RE: Monument Ridge – Retail Paint Store Final PUD Plan

Your Final PUD Plan for Monument Ridge – Retail Paint Store has been reviewed by outside agencies and Town Staff. Comments and necessary revisions have been compiled and are provided below. Some items are summarized in the interest of being concise and clear. Names and contact information are provided should you need to discuss any of the comments with the specific reviewer. Town comments are provided at the end of the letter; duplicate comments have been removed for your convenience. There may be additional comments/revisions as a result of your response to this first round of comments. We are happy to discuss any of these items, if necessary.

SITE PLAN
705 W. BAPTIST RD.
705 WEST BAPTIST ROAD, MONUMENT CO

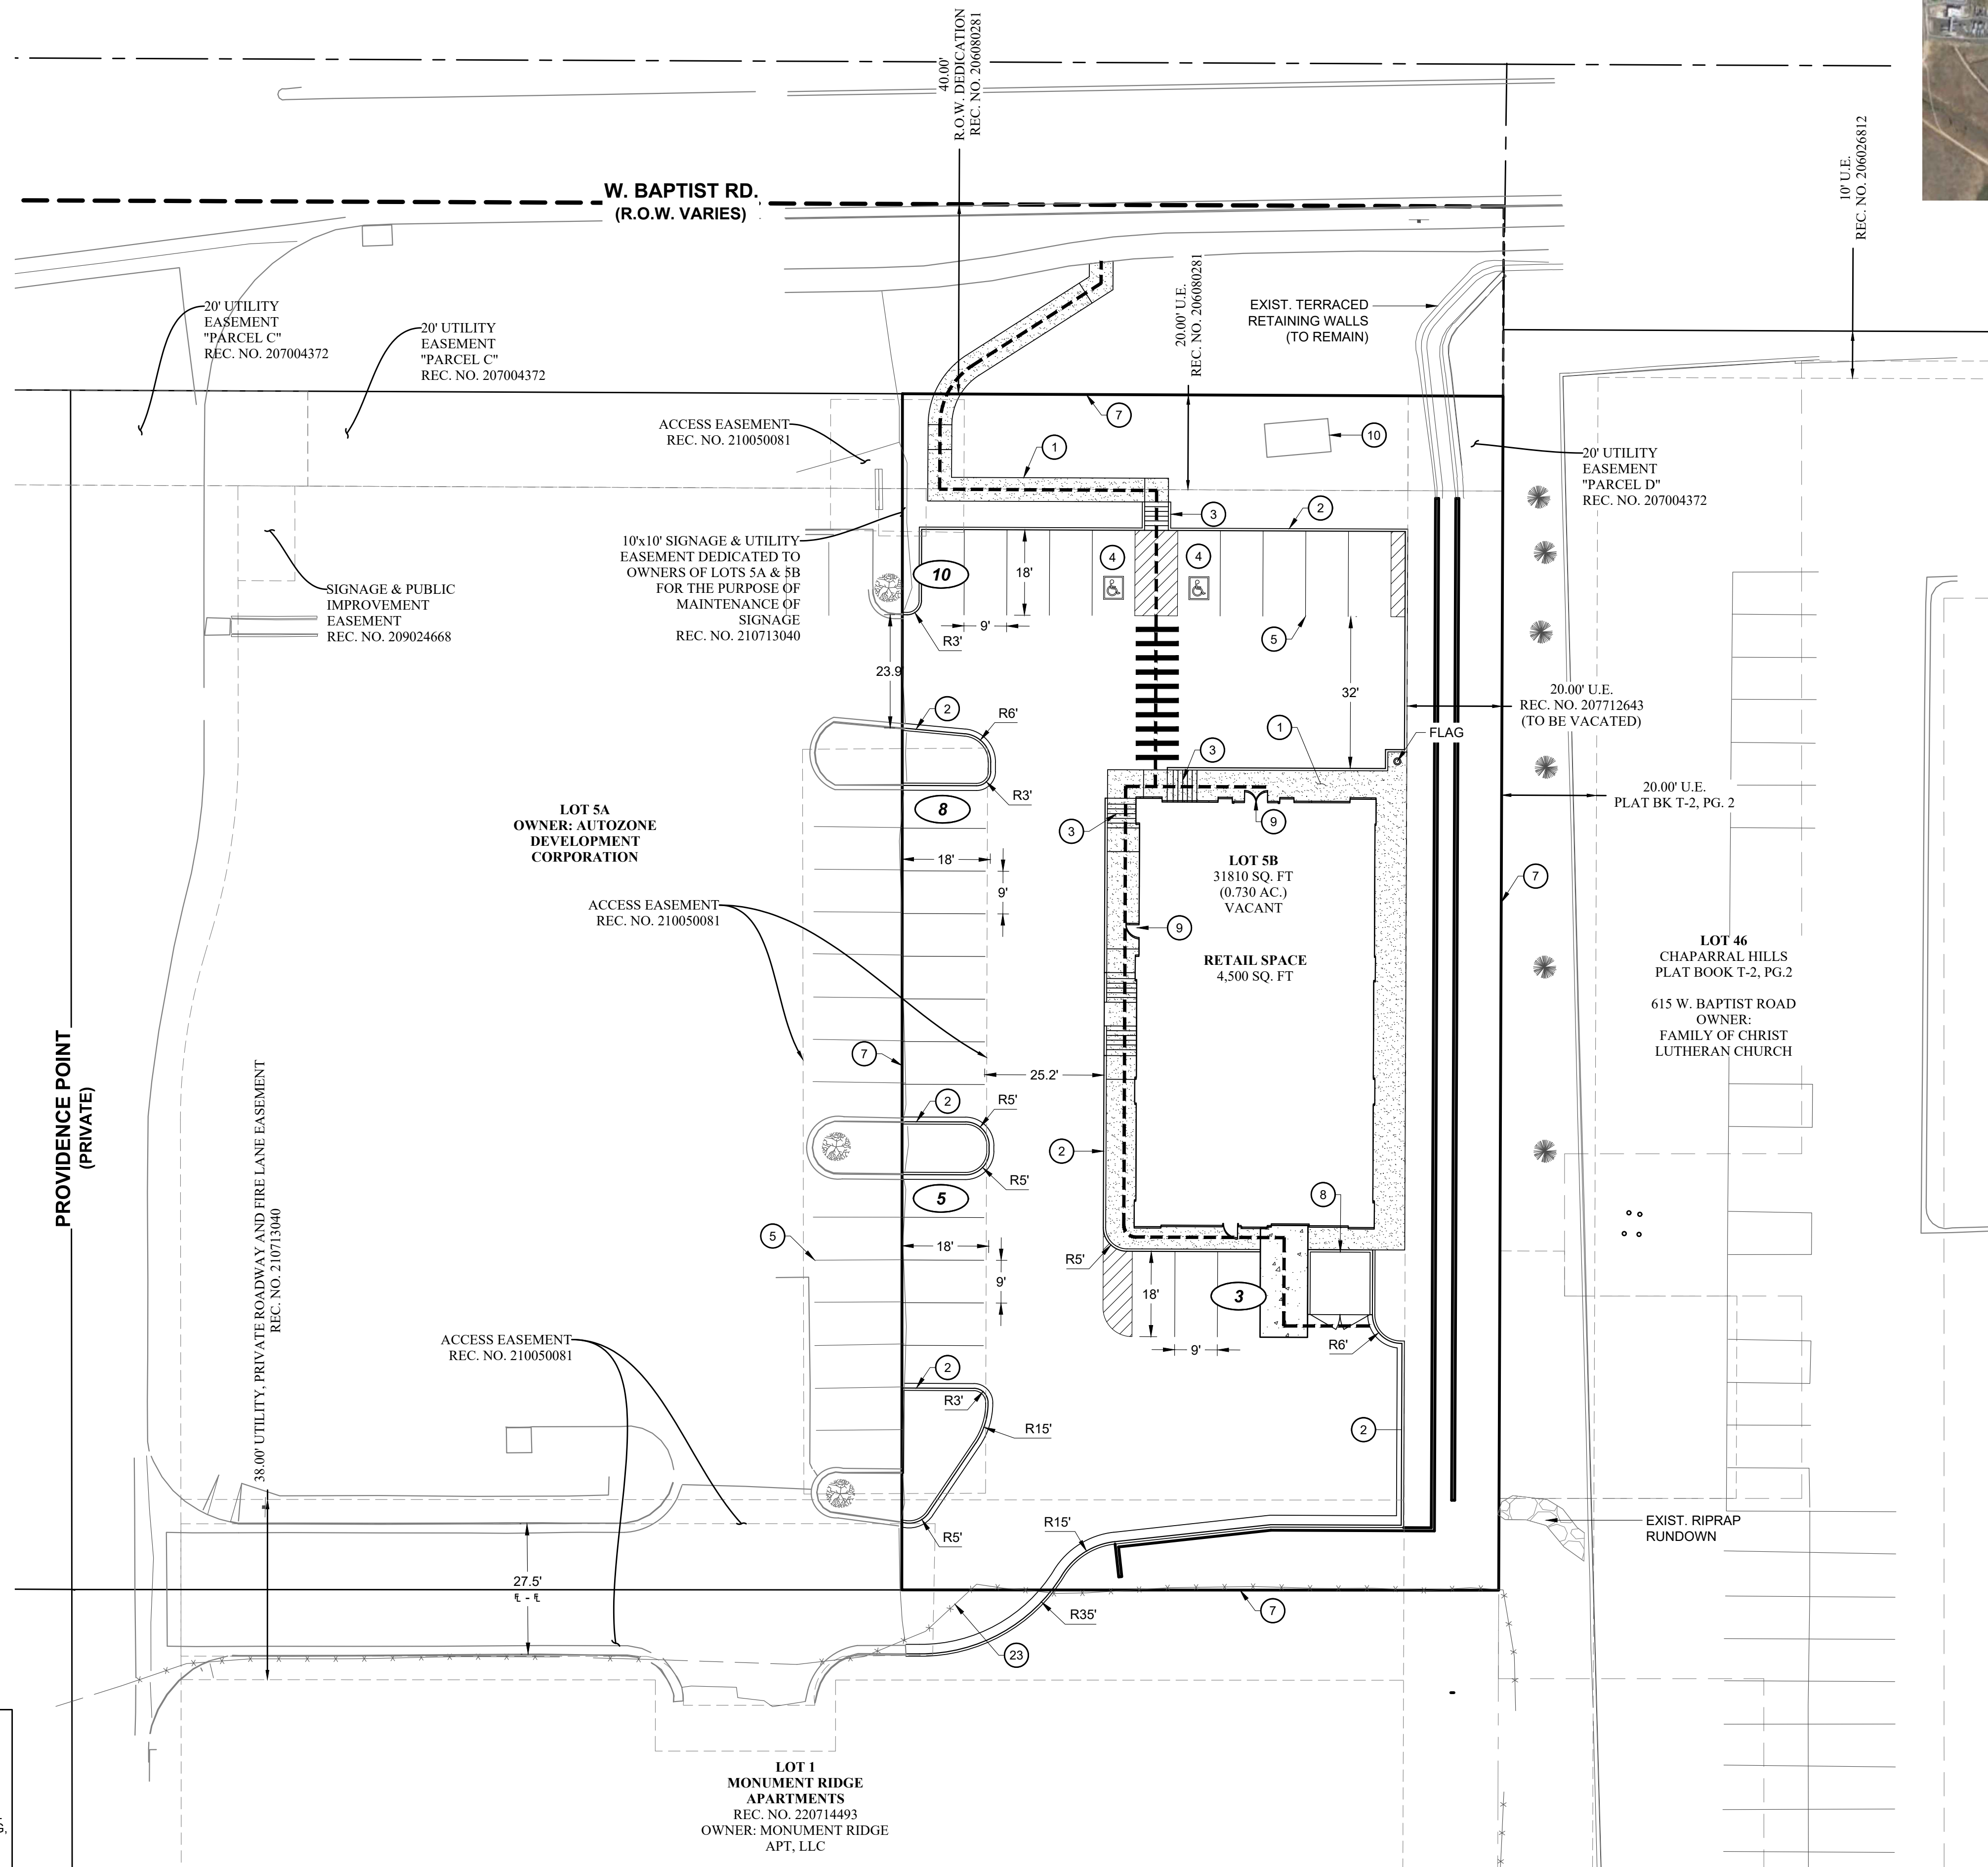
1. The Site Data Chart should be expanded to include applicable data as required in the Final PUD checklist (e.g., min./max. dimensions, bulk standards, etc.).

2. A symbol is missing in the Legend for Proposed Site Lighting.

3. Call out crosswalk bars.

4. There are no proposed signs shown but there is a proposed sign symbol in the legend. Please show any proposed signing.

5. Both ADA parking stalls need to be signed. The left stall should be signed as "Van Accessible".

6. Proposed asphalt drive hatch doesn't clearly define where pavement limits stop especially at southwest corner of property. Will pavement extend to Providence point?

7. Plans do not call out two sets of lines east of the retail space. It is assumed that they are walls

based on the location of the existing walls, but this should be clarified.

EES Response: Added.

EES Response: Added.

EES Response: Call-out added.

EES Response: Signs in legend now needed.

EES Response: Signage added.

EES Response: Additional hatch added to demonstrate more clearly extents of paving.

EES Response: Additional annotations now provided.

705 W. BAPTIST RD.
PRELIMINARY SITE PLAN

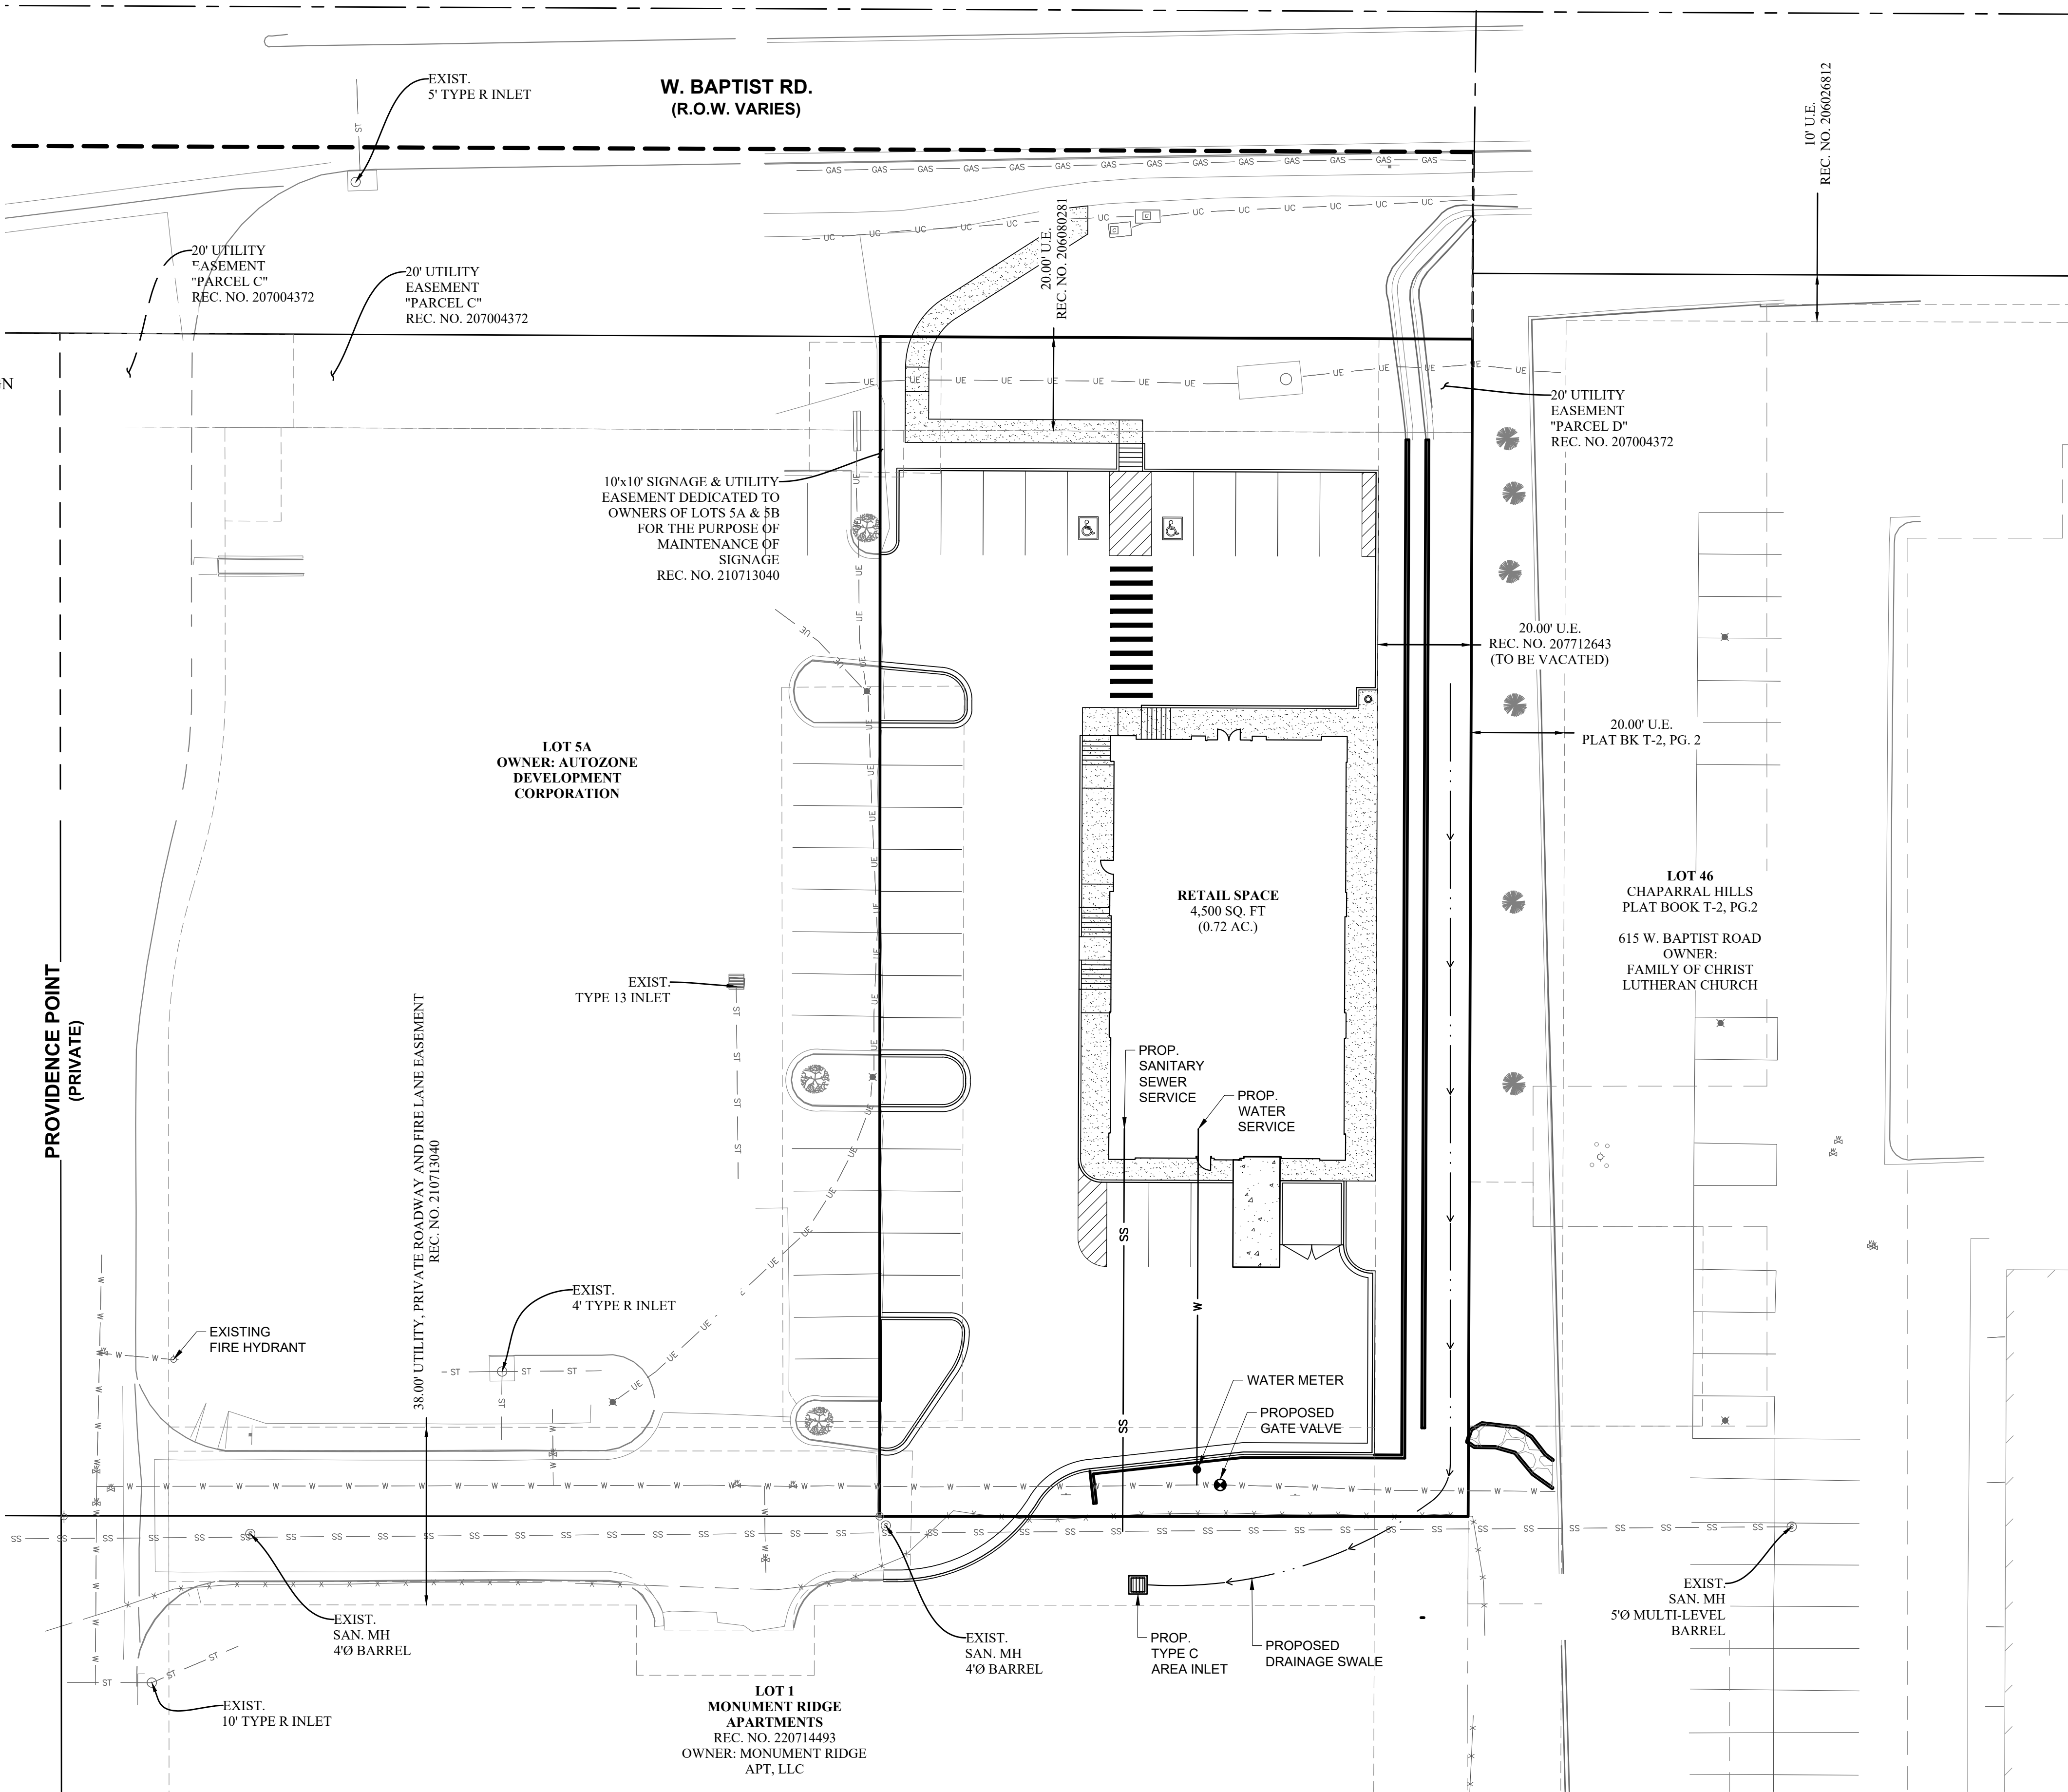
1. Sheet is identified as “Preliminary” Utility Plan. Final PUD checklist requires a “Final” utility plan.

2. Proposed services such as gas, electric and telecom should be shown.

3. Boxes north of the site should be identified (e.g., transformer, pull-box, etc.)

4. A separate tap and meter for irrigation should be shown, if provided.

5. The purpose of the proposed gate valve just east of the proposed water service tap should be confirmed.

6. Dimension between water and sanitary sewer services should be provided.

7. There is a potential conflict between the proposed wall and existing water line, near the south driveway access.

8. Existing and proposed water and sanitary sewer line diameter, length, slopes, and inverts should be identified.

9. Other plan sheets identify an 18” storm pipe in the adjoining Monument Ridge Apartments tract to the south. This should be added to this sheet. Is the storm pipe existing or proposed?

10. Missing sanitary sewer/water line crossing callouts (e.g., depth of existing water relative to tie in location of sanitary sewer).

EES Response: Revised.

EES Response: Now shown.

EES Response: Annotations added.

EES Response: Triview Metro indicated their preference for an inside meter setting. The irrigation now pulls off interior to the building after the meter.

EES Response: Removed.

EES Response: Added.

EES Response: The wall here is only a landscape wall, <18” over waterline.

EES Response: Added.

EES Response: It was assumed that this pipe was to be constructed by the apartments which is under construction now, but it was not, so after discussions with Tom Martinez of the Town, he agreed to allow discharge to the private road flowline after water quality treatment in a Type C inlet.

EES Response: Service layout revised.
